**NELSON GEOTECHNICAL
ASSOCIATES, INC.**

December 17, 2021

Critical Areas Study and Geotechnical Plan Review
Moran Residence Development
5000 West Mercer Way
Mercer Island, Washington
NGA File No. 1211520

SHEET NUMBER
C-03

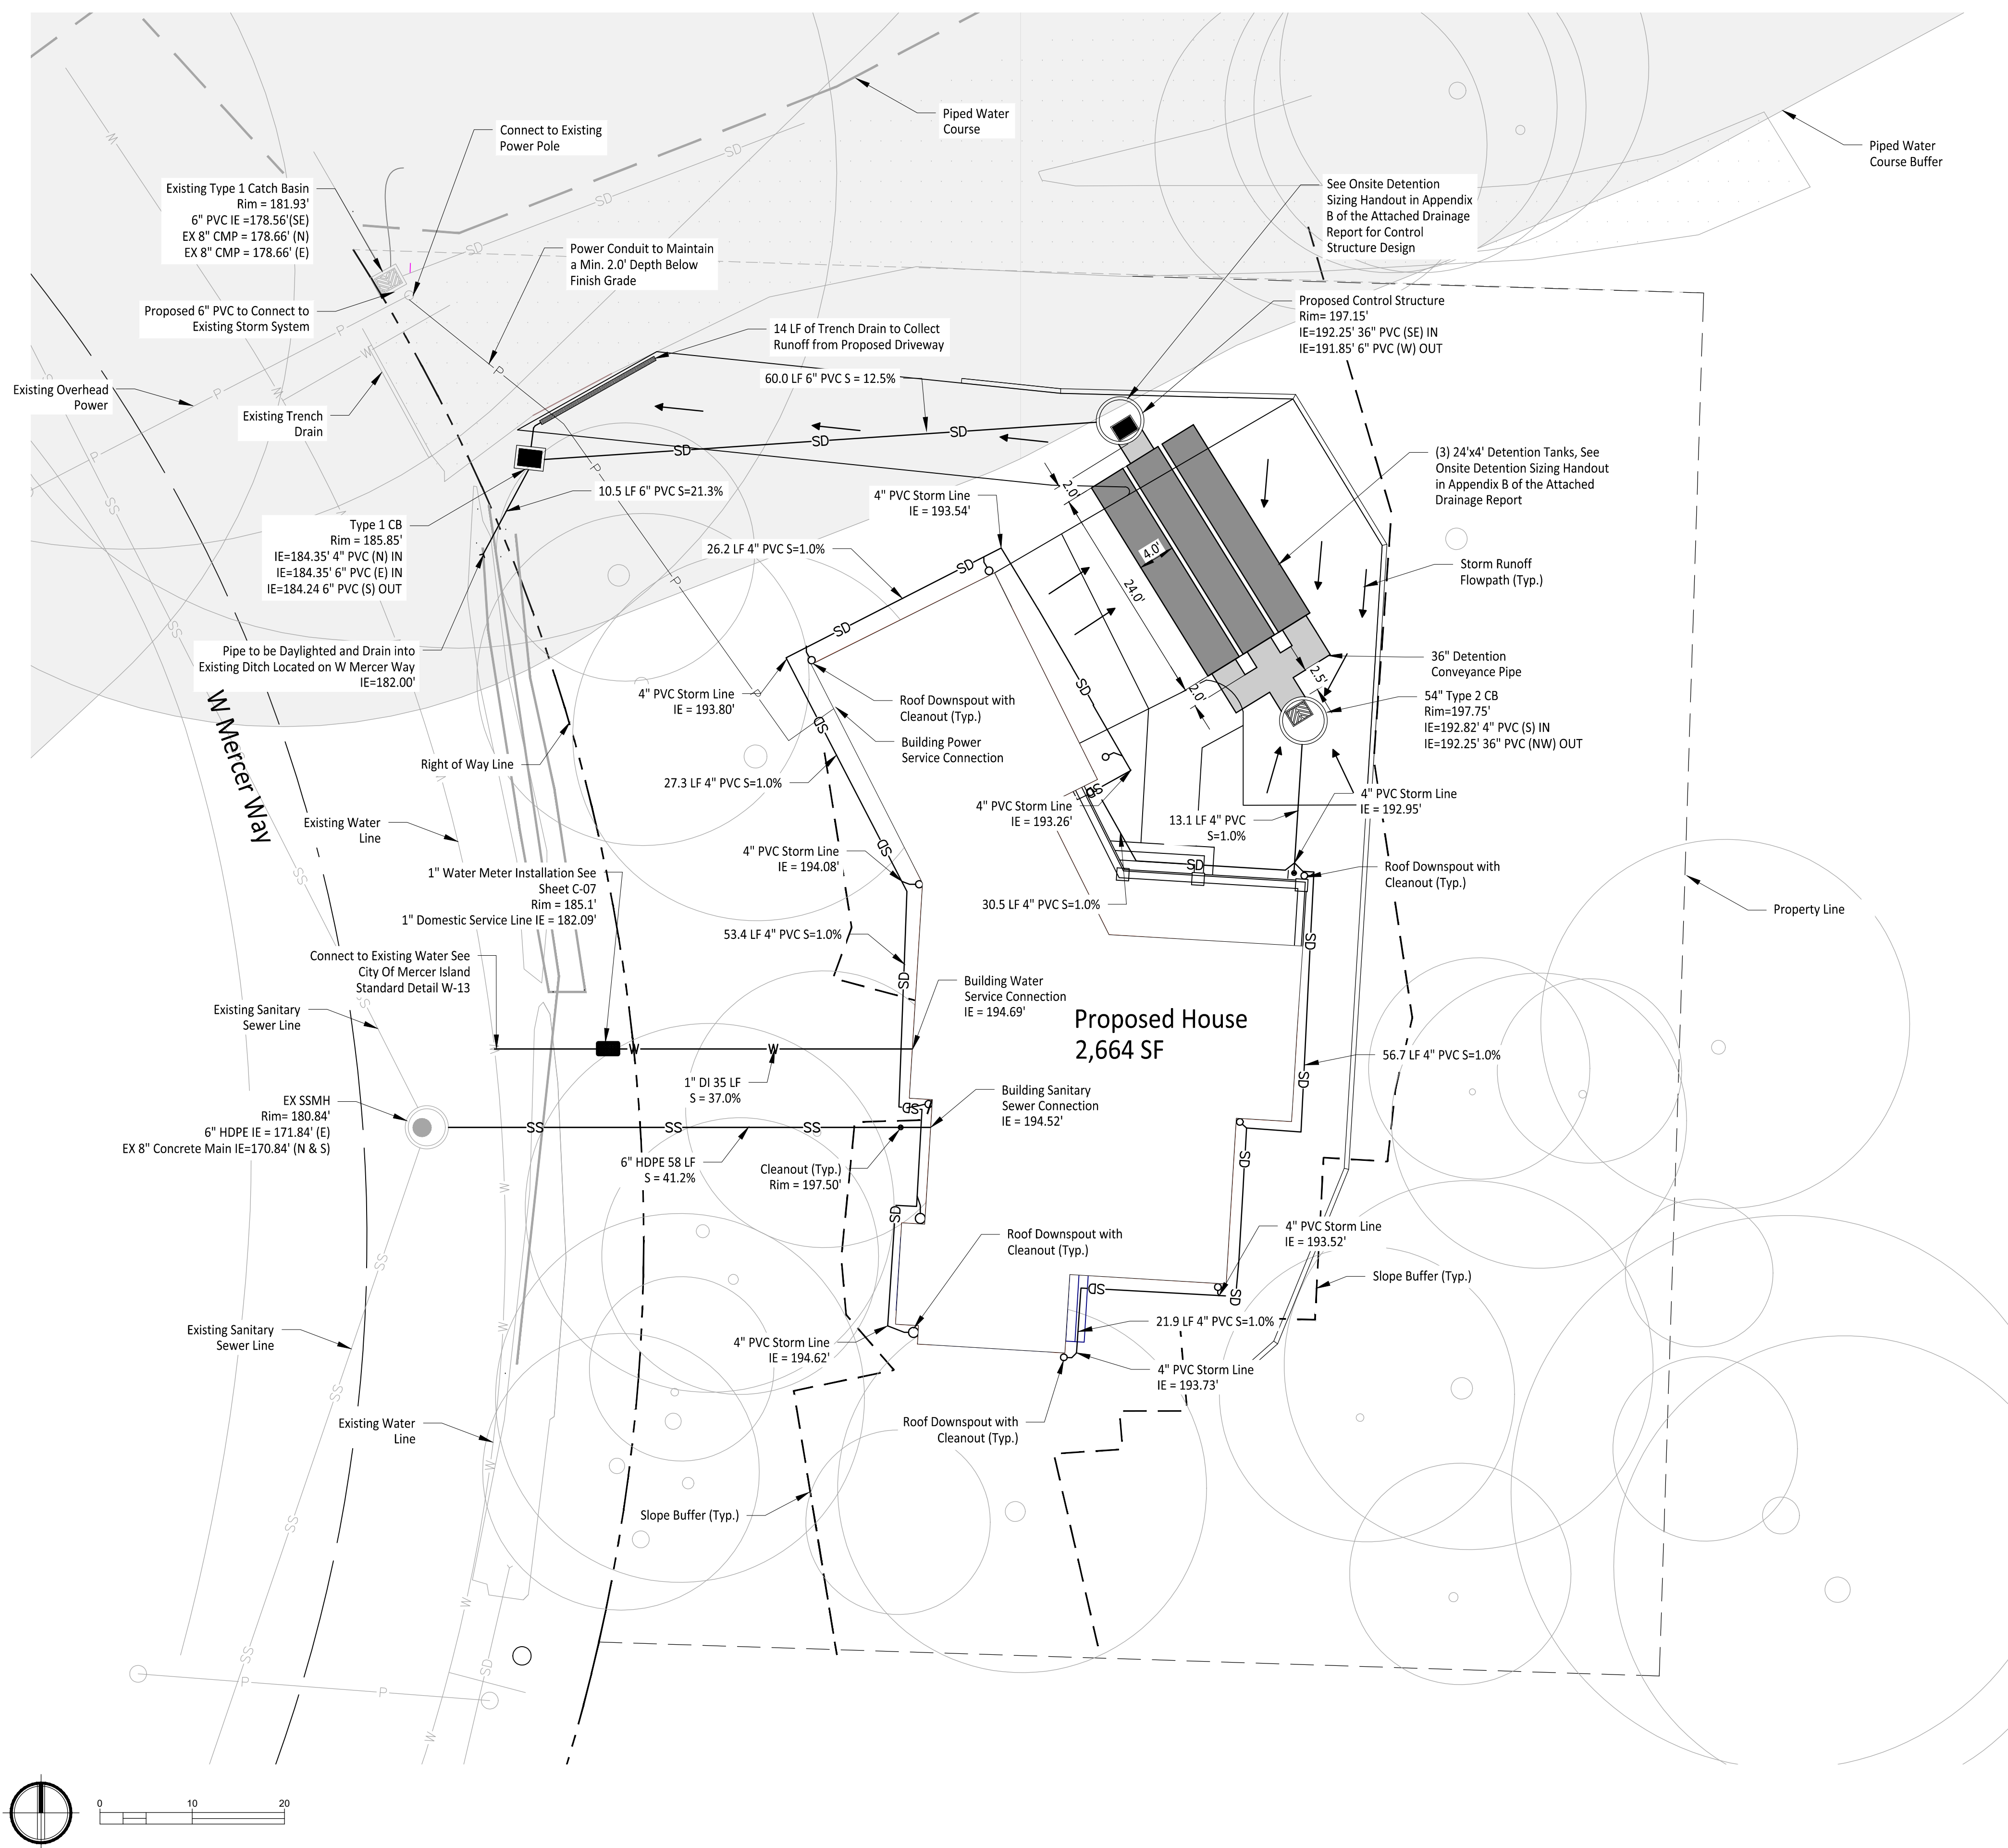
Utility Installation: The Utility Plan on Sheet C-03 shows water and side sewer connections between the residence and West Mercer Way to the west. Resulting temporary excavations for utility connections over the steeply sloping areas should be temporarily shored as necessary. Temporary slopes on the site should be no steeper than 1.5H:1V. The contractor should develop plans to facilitate safe worker access and prevent instability during temporary utility excavations. We are able to provide consultation and review of utility excavation plans during construction, as warranted.

Backfill of utility trenches over steep slopes should be performed in level, benched lifts, and not be completed in sloping lifts. Recommendations for trench backfill are outlined in the revised geotechnical report and should be followed strictly.
